Salmon Planning Company

DF/PL.4293

13 February 2024

Proposed non-material amendment to the dwelling granted approval pursuant of the reserved matters ref. 2022/0484/REM at Somerleaze House, Wookey

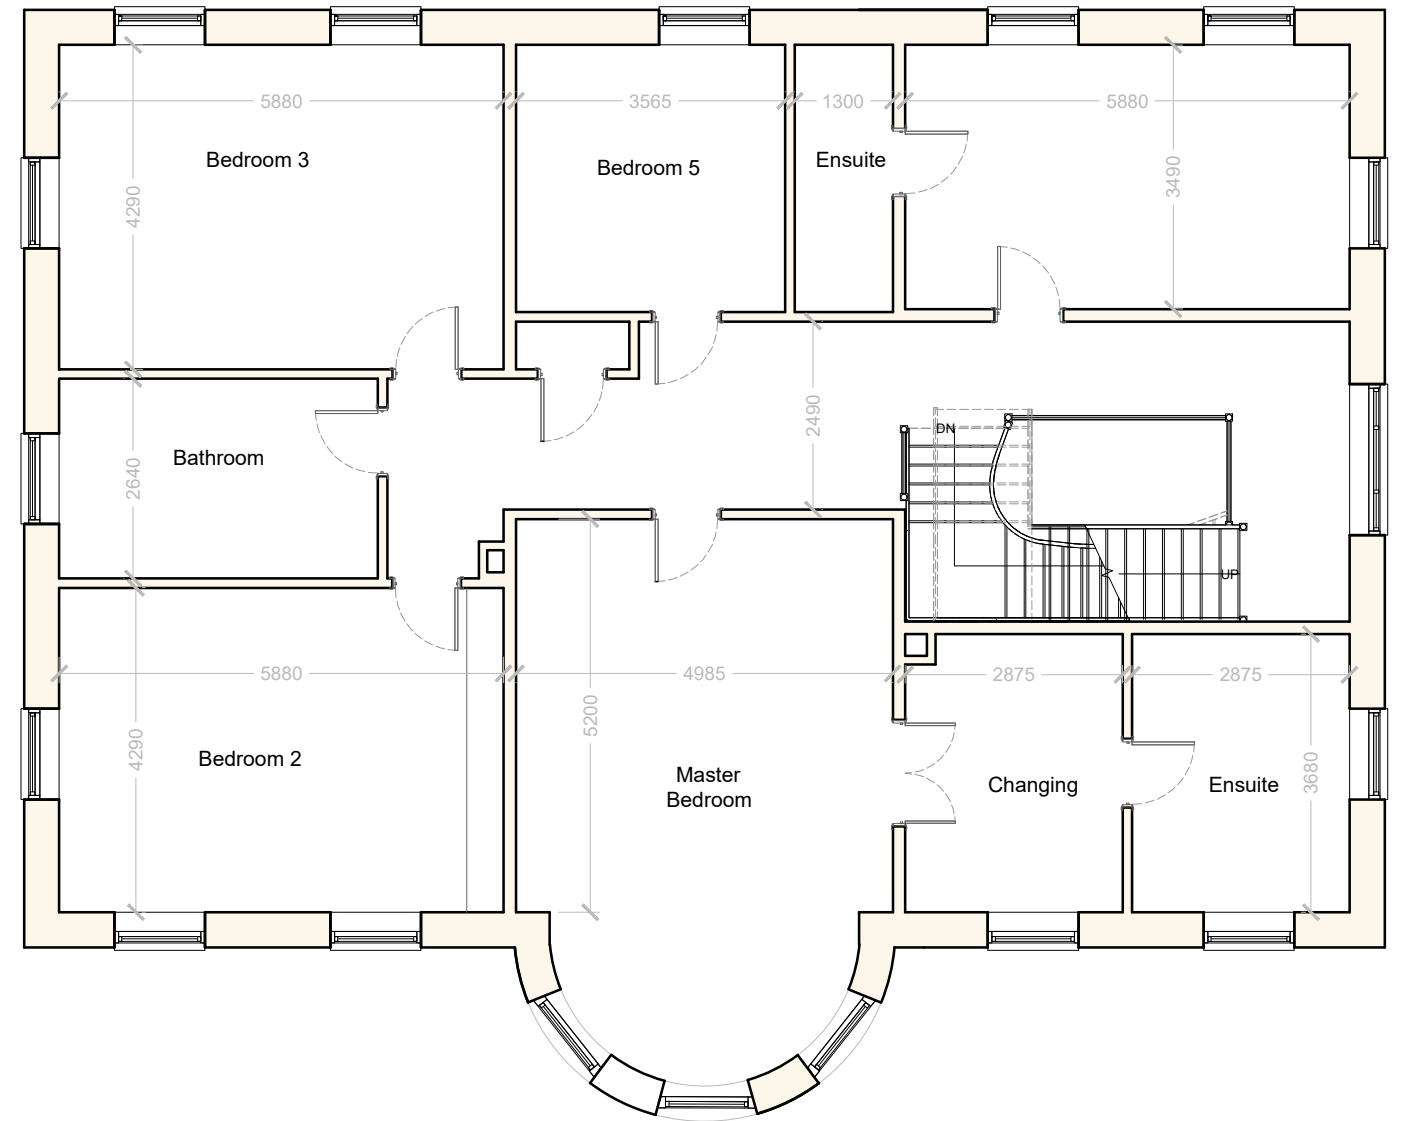
- On the approved north elevation, the projecting circular bay has a centrally positioned pair of French doors serving the drawing room. These doors are proposed to be omitted in lieu of a window in the same position. The proposed window would match the adjacent windows in style and design as shown on drawing PL4293/6B.
- The approved dwelling has a basement level which would not been seen externally, except on the approved east elevation. The Applicant has decided to omit the basement from the development in its entirety, so the revised east elevation (drawing PL4293/7B) shows the omission of the external basement element.
